From [REDACTED]
Sent: 12 June 2018 10:48
To: Planning.Responses
Cc: Michael Eastham; Derek Whittington
Subject: AL/20/18/OUT - Outline application for erection of 27 dwellings and access to A29 Lidsey Road, Lidsey - WSCC Highways and Transport response dated 12th June 2018

TO:	Arun District Council FAO: Michael Eastham
FROM:	Highways, WSCC – Tim Townsend
DATE:	12 th June 2018
LOCATION:	Land at Bridge Cottage and The Old Cottage, Lidsey Road, Lidsey, PO22 9PH
SUBJECT:	AL/20/18/OUT Outline application with all matters reserved for the demolition of 2 No. dwellings & associated outbuildings & the erection of up to 27 No. dwellings, of which 30% will be affordable, with associated open space & access. This application is a Departure from the Development Plan.
DATE OF SITE VISIT:	30 th May and 4th June 2018
RECOMMENDATION:	☒ Advice ☒ Objection ☐ Modification ☐ No Objection ☒ More Information ☐ Refusal
S106 CONTRIBUTION TOTAL:	£TBA

This is the WSCC highways and transport response to the above outline planning application with all matters reserved for the demolition of 2 No. dwellings & associated outbuildings & the erection of up to 27 No. dwellings, of which 30% will be affordable, wi

Figure 4.1 – Illustrative Site Plan

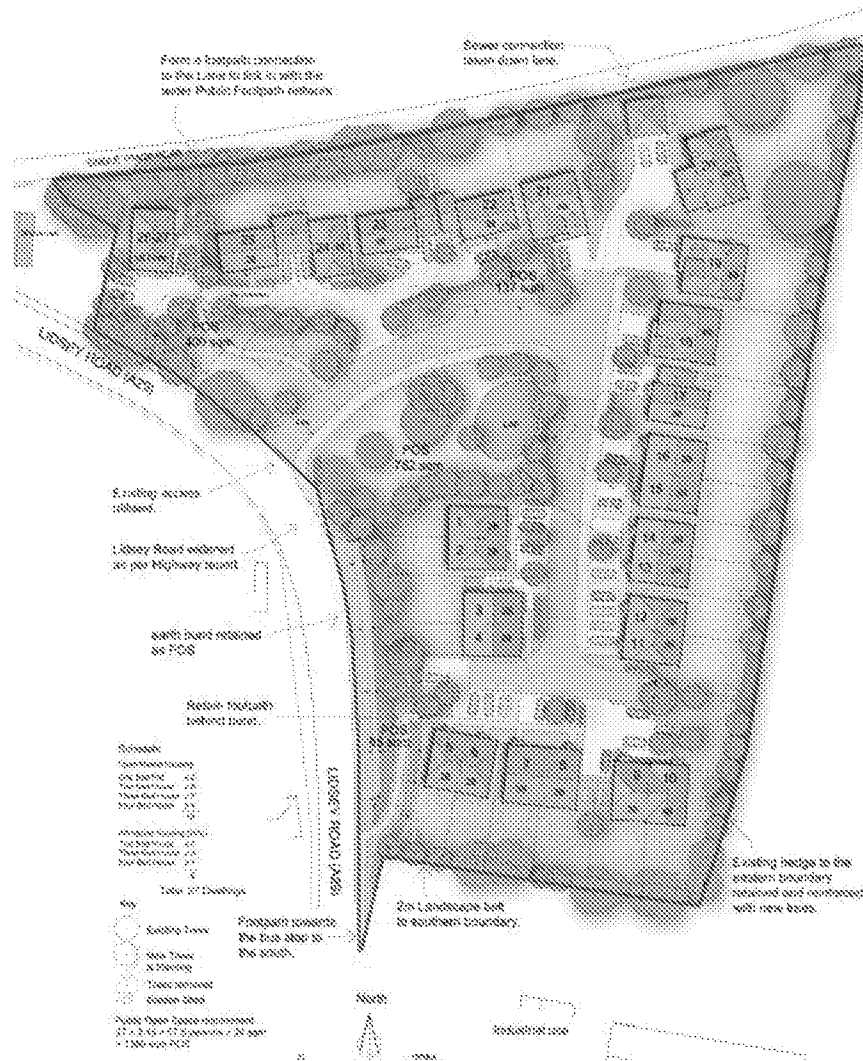
The internal layout is shown indicatively on drawing 1749-02B. As submitted, it would not be suitable for adoption under S38 given lack of suitable service margins. Also, it is not known what form of surface water drainage is proposed for the site which might itself dictate whether the layout can or can't be adopted.

With regard to access by refuse and fire appliances, the access drive shown to plots 22-27 might need widening as in places it looks slightly restrictive (particularly adjacent to plots 25-27). As such, this would have to be considered further at any RES/DOC stage.

Project		
OLD COTTAGE LIDSEY		
New Access Design		
Drawn	Date	Scale (at A3)
TE	19/07/2018	1:500
Doc no.	Revision No.	
OCL/SR/701	C

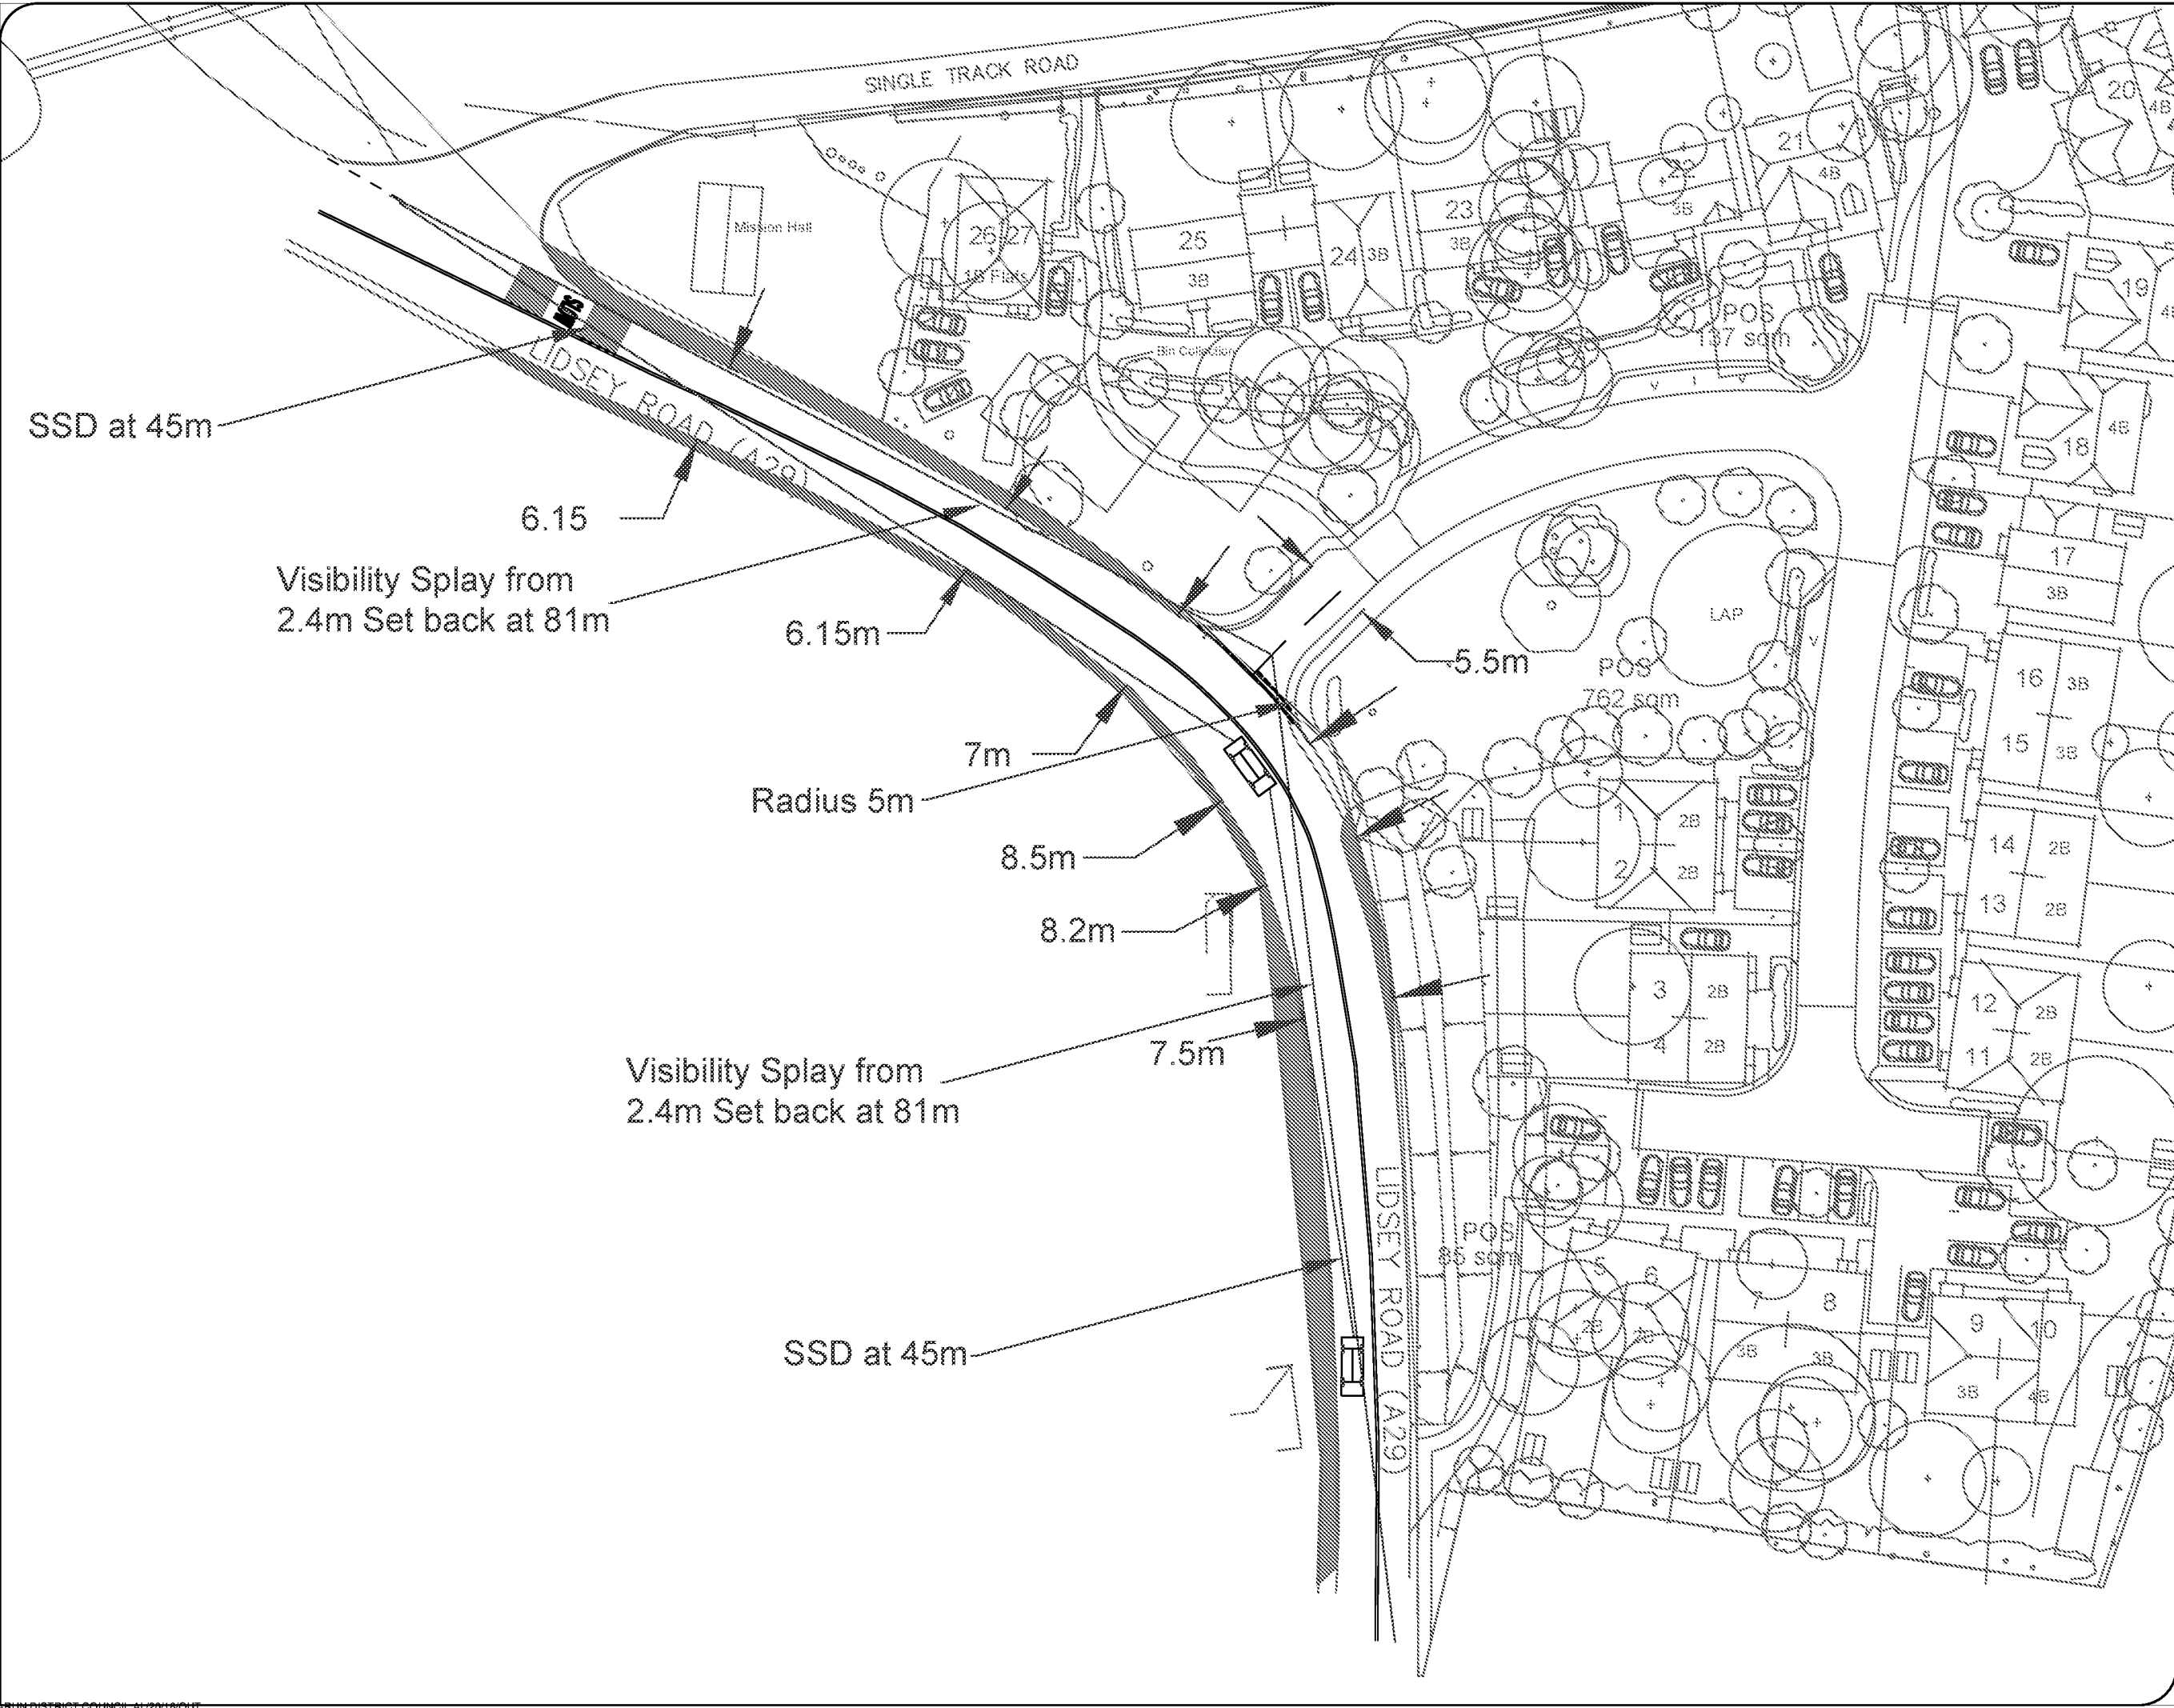
As mentioned above, vehicular access is shown directly off the A29 on the apex of a bend in the road. The access measures 4.8m wide with what appears to be 5.0-6.0m bellmouth radii (this should be clarified and marked-on a plan). Visibility splays are taken from a 2.4m 'x' distance with major road ('y'), with the applicant's Transport Consultant stating that splays of 106m in the leading traffic direction can be provided - looking west from the access - (98m scales on the plan) and 150m in the trailing direction - looking south - (79m scales on the plan). Forward visibility (i.e. that required for drivers of vehicles turning right and left into the site and corresponding visibility for drivers already on Lidsey Road coming-across them - from both north and south) is stated as being 81m (although approximately 60m scales from the drawing between a right turning vehicle and driver of a vehicle travelling southbound). No northbound forward visibility splay is shown for vehicles driving northwards coming across a vehicle turning right into the site.

Given the lack of clarity including lack of marked-on dimensions and visibility splays - it is not known what can actually be provided - both on and off-site. For the CHA to consider the matter further, the above matters should be attended to - a summary of which is provided below (other requirements are summarised elsewhere in this report under relevant sections):

- The dimensions of bellmouth radii of new junction
- The achievable visibility splays taken from 2.4m 'x' distance with dimensions marked-on
- The forward visibility both for vehicles travelling north AND south encountering a vehicle waiting to turn into the site with dimensions
- Dimensions of carriageway at and on the approach to the site entrance (and site entrance itself)

- Visibility information and SSD to right turning vehicles as required as above
- Vegetation areas required for visibility purposes shown more clearly
- Road markings that are proposed at and on the approaches to the new access point and how these comply with the Traffic Signs Manual
- A Design Commentary setting-out how the design complies with guidance and/or design standards
